**KITTITAS COUNTY
LAND USE HEARING EXAMINER**

CU-24-00005

Red's Fly Shop

**FINDINGS OF FACT,
CONCLUSIONS OF LAW, AND
DECISION AND
CONDITIONS OF APPROVAL**

SITE PLAN

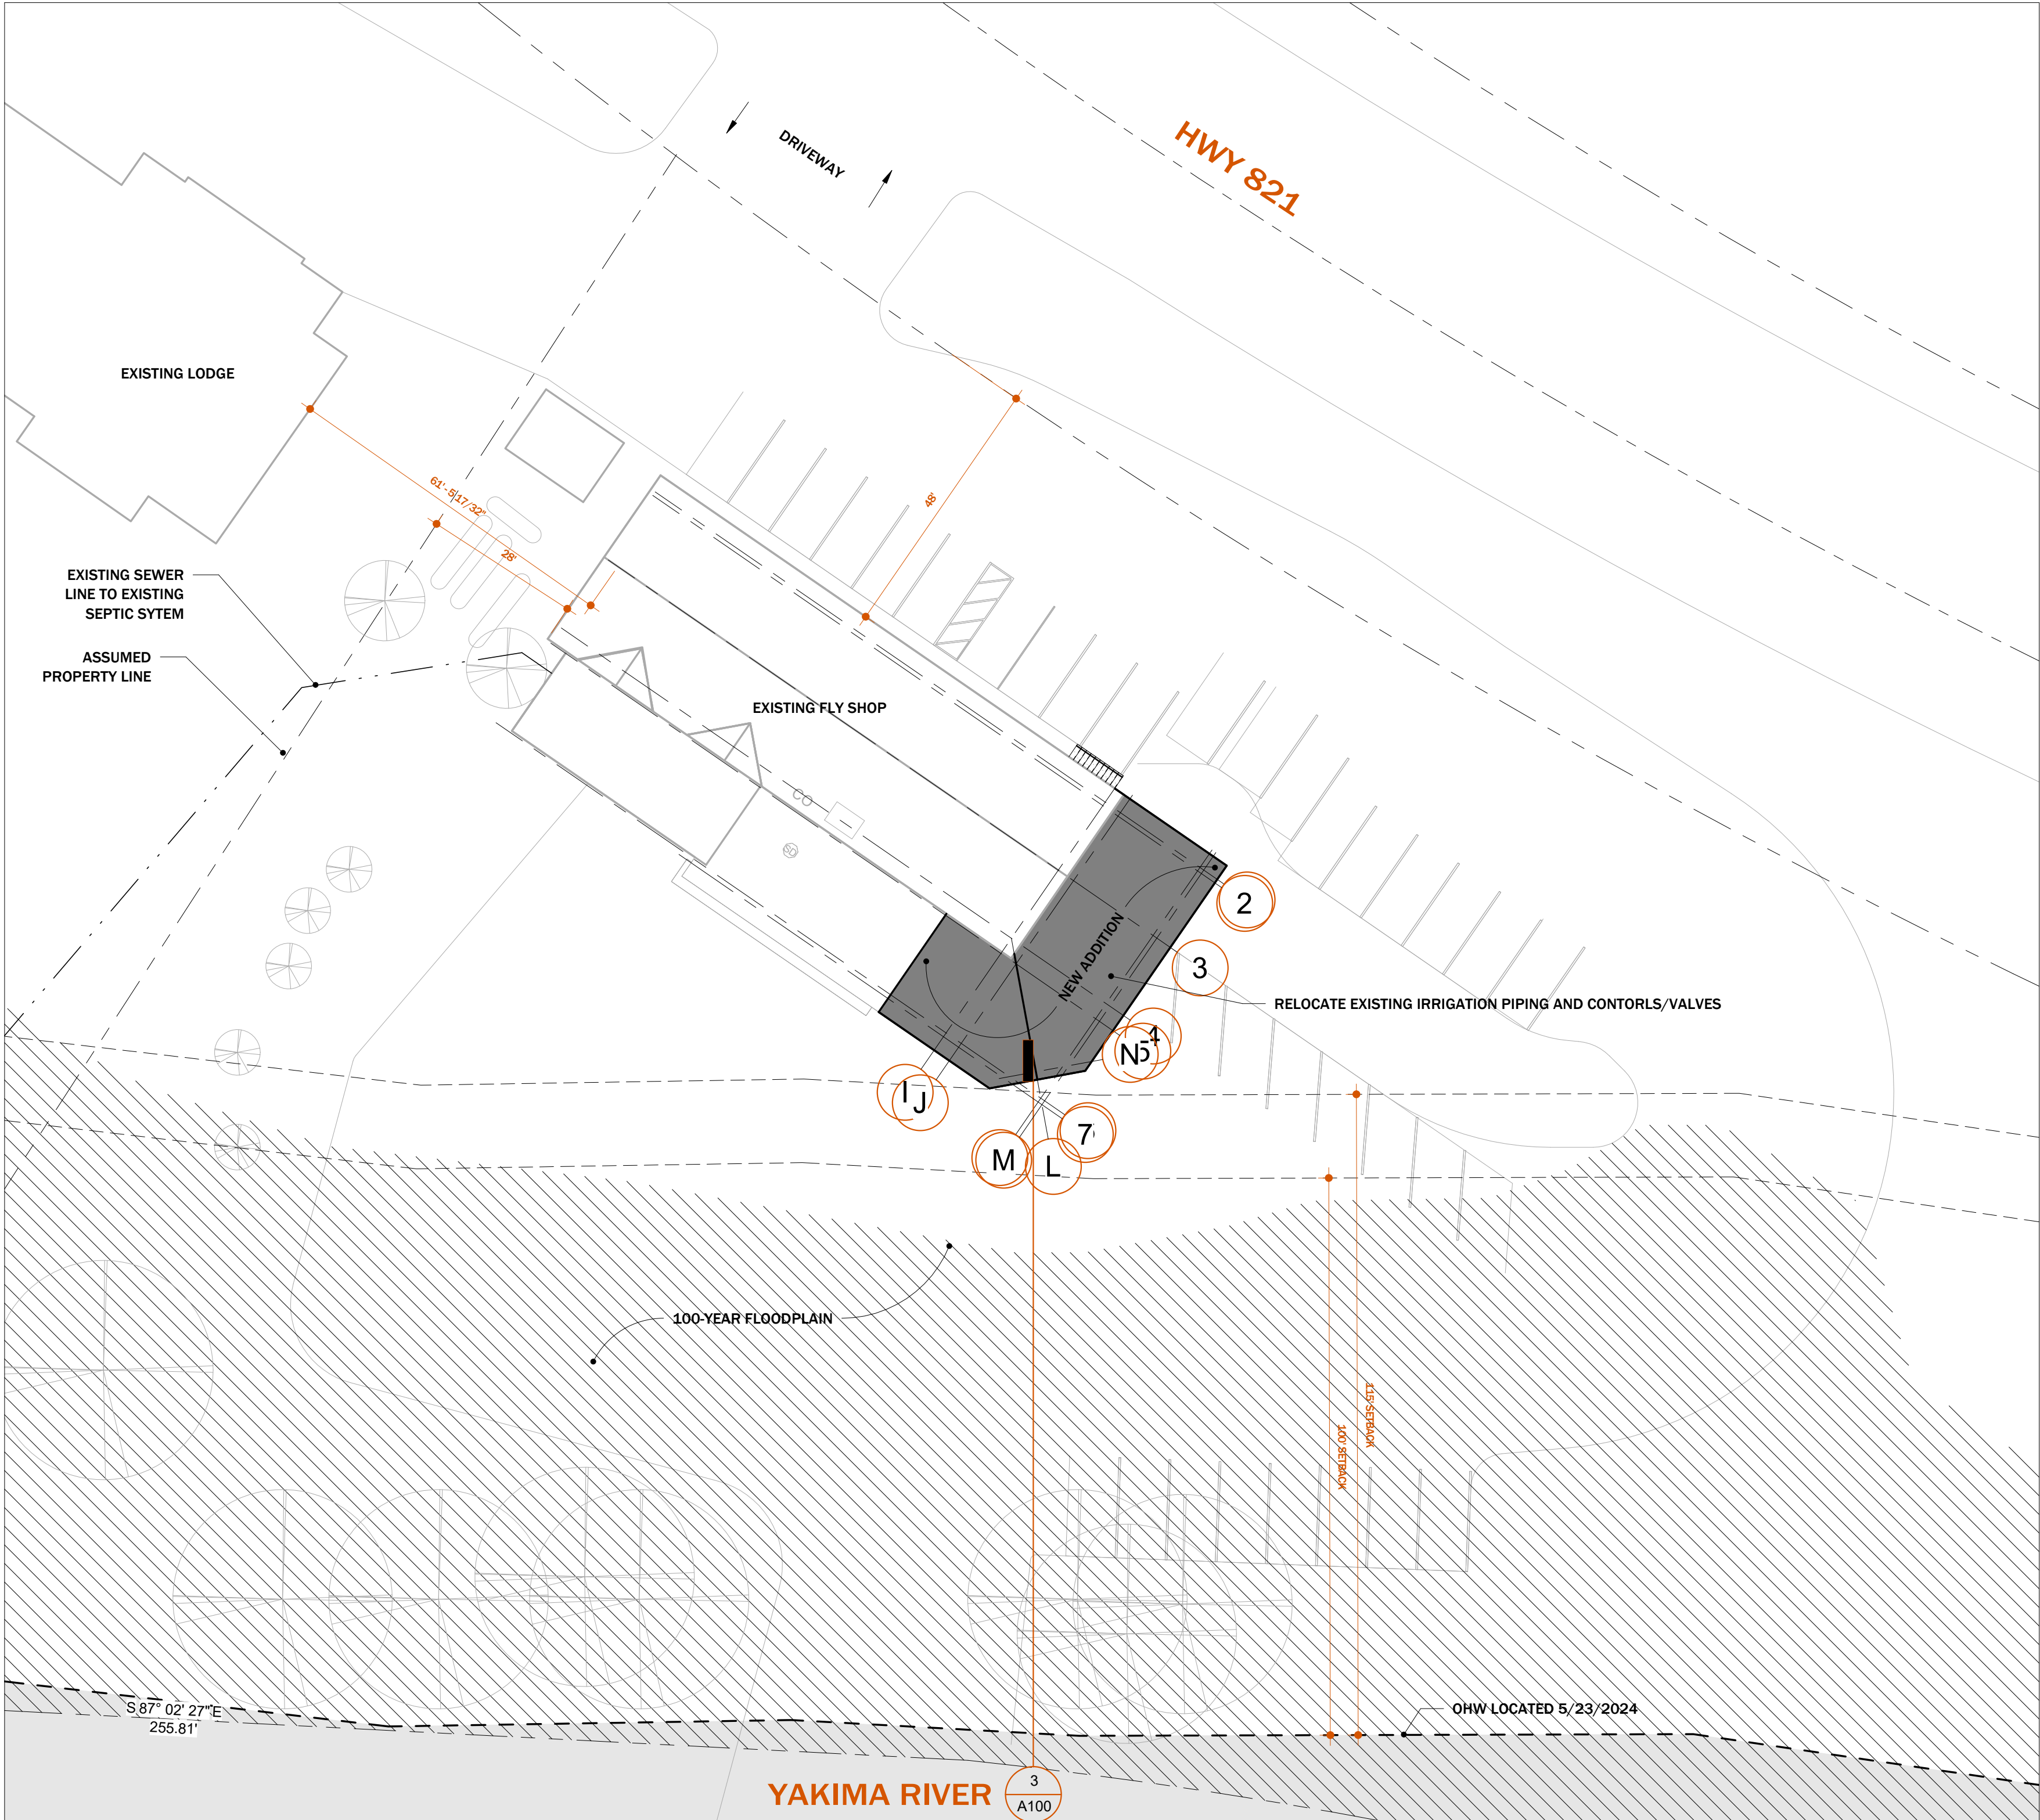
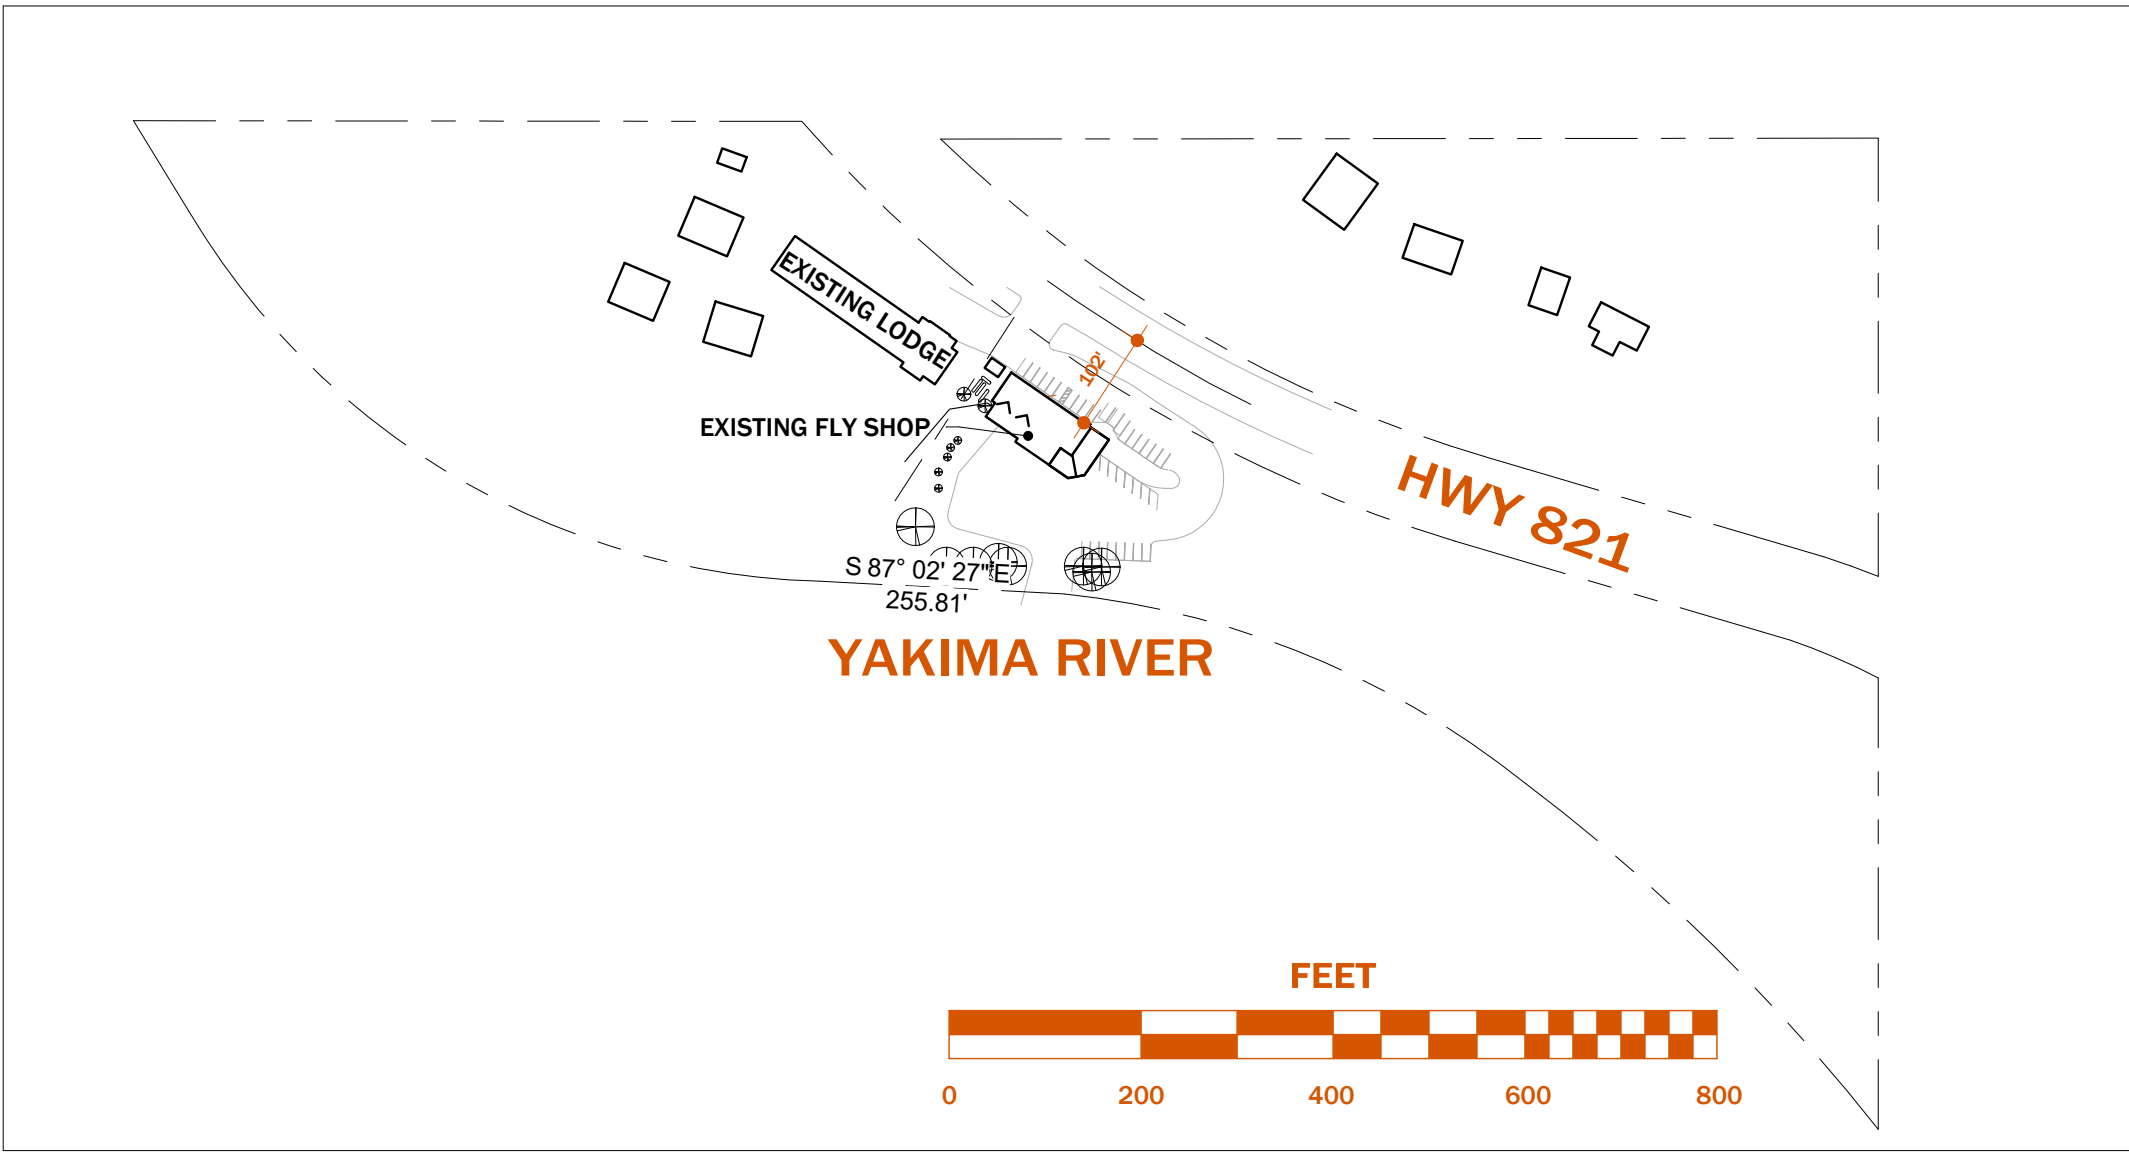
- 13.8. Kittitas County Public Works: Kittitas County Public Works provided comments regarding grading/filling permit requirements. KCPW also provided floodplain development specifications. In addition to these circumstantial requirements, KCPW also stated that the applicant needs to revise their site plan to show the floodplain as a visible layer.

- 13.8.1. Hearing Examiner Finding: As the applicants have revised their site plan and KCPW has indicated that the new site plan is adequate.
- 13.9. Public Comments: No comments were received from the public during the established comment period.
